Recommendation Report for Planning Permission for Works or Extension to a Dwelling

REF NO: EG/15/19/HH

LOCATION: 5 Critchmere Road
Eastergate
PO20 3XA

PROPOSAL: Retention of conservatory & flue.

Roof profile + ground floor plan 1:100 @ A4
 Drg no. 02

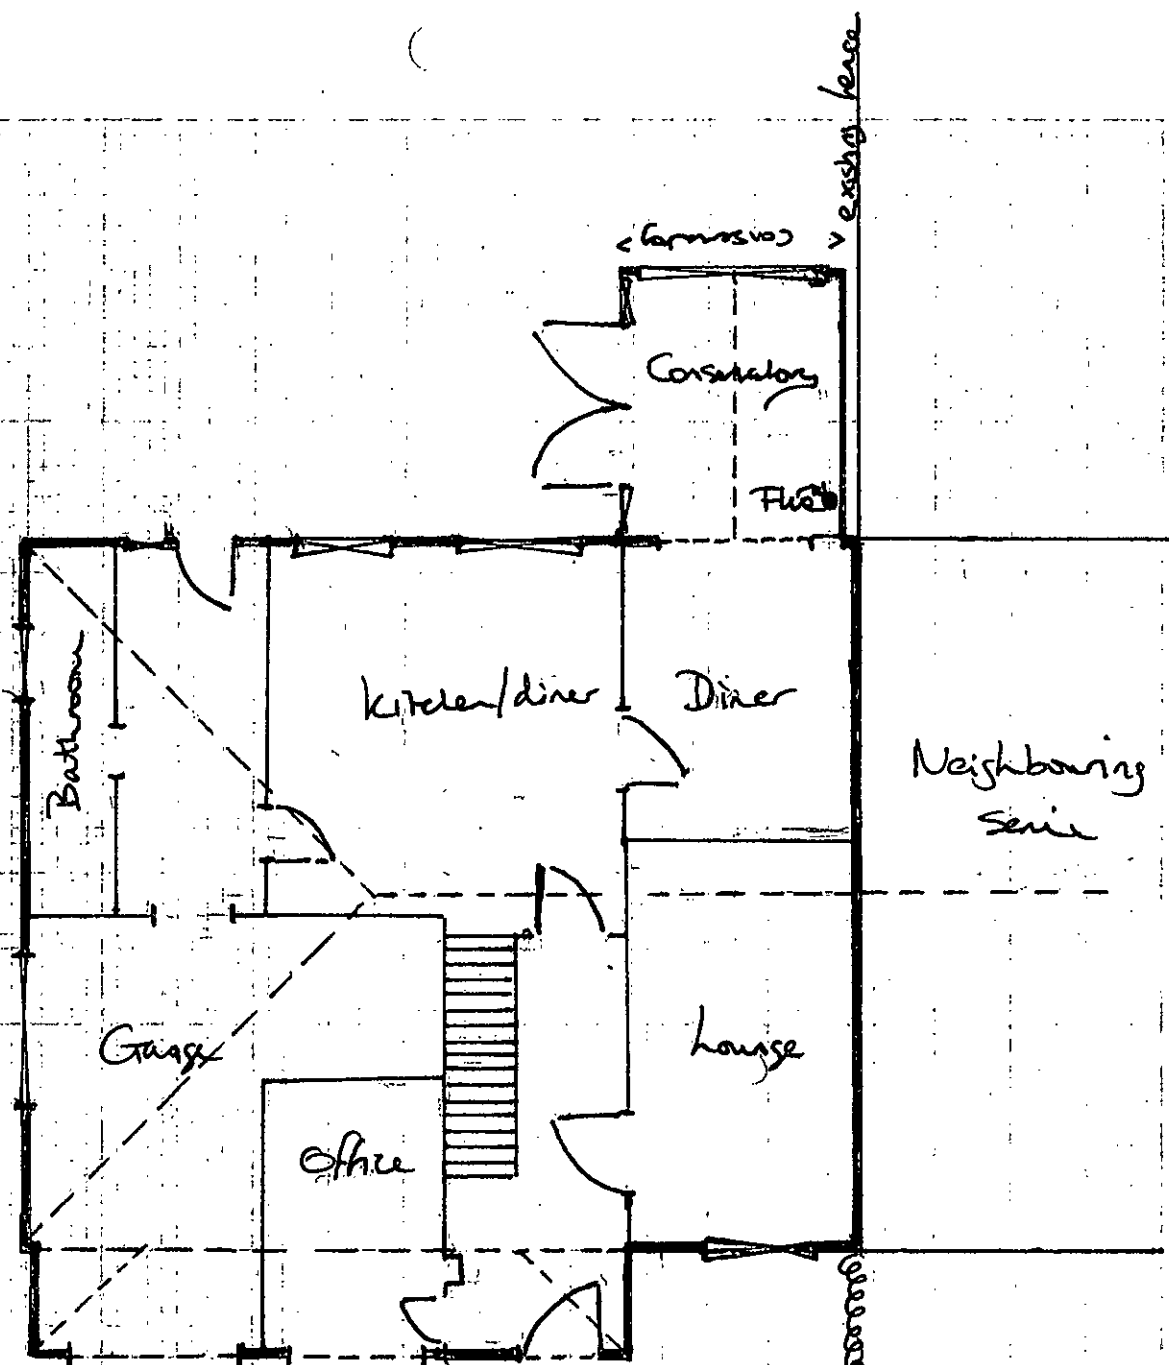
The conservatory is constructed to a depth of 3.6m and a height of 3.10m. It is situated close to the boundary to the north, however the conservatory is only around 0.6m larger in depth than that which could be constructed without permission as a result it is not considered to give rise to any adverse overbearing or overshadowing upon neighbouring amenity.

The flue extends from the conservatory and runs along the rear wall of the property with a height approximately 1.6m above the eaves and 1.65m below that of the ridge height of the host dwelling. Whilst this is positioned close to the neighbouring property and is quite high the size would ordinarily fall under permitted development. In this case as it is connected to the conservatory which requires

At its current siting and height, it cannot be argued that any impacts upon residential amenity are significant in which a refusal is justified.

The positioning of a flue normally needs consent under other legislation to ensure it is safely positioned.
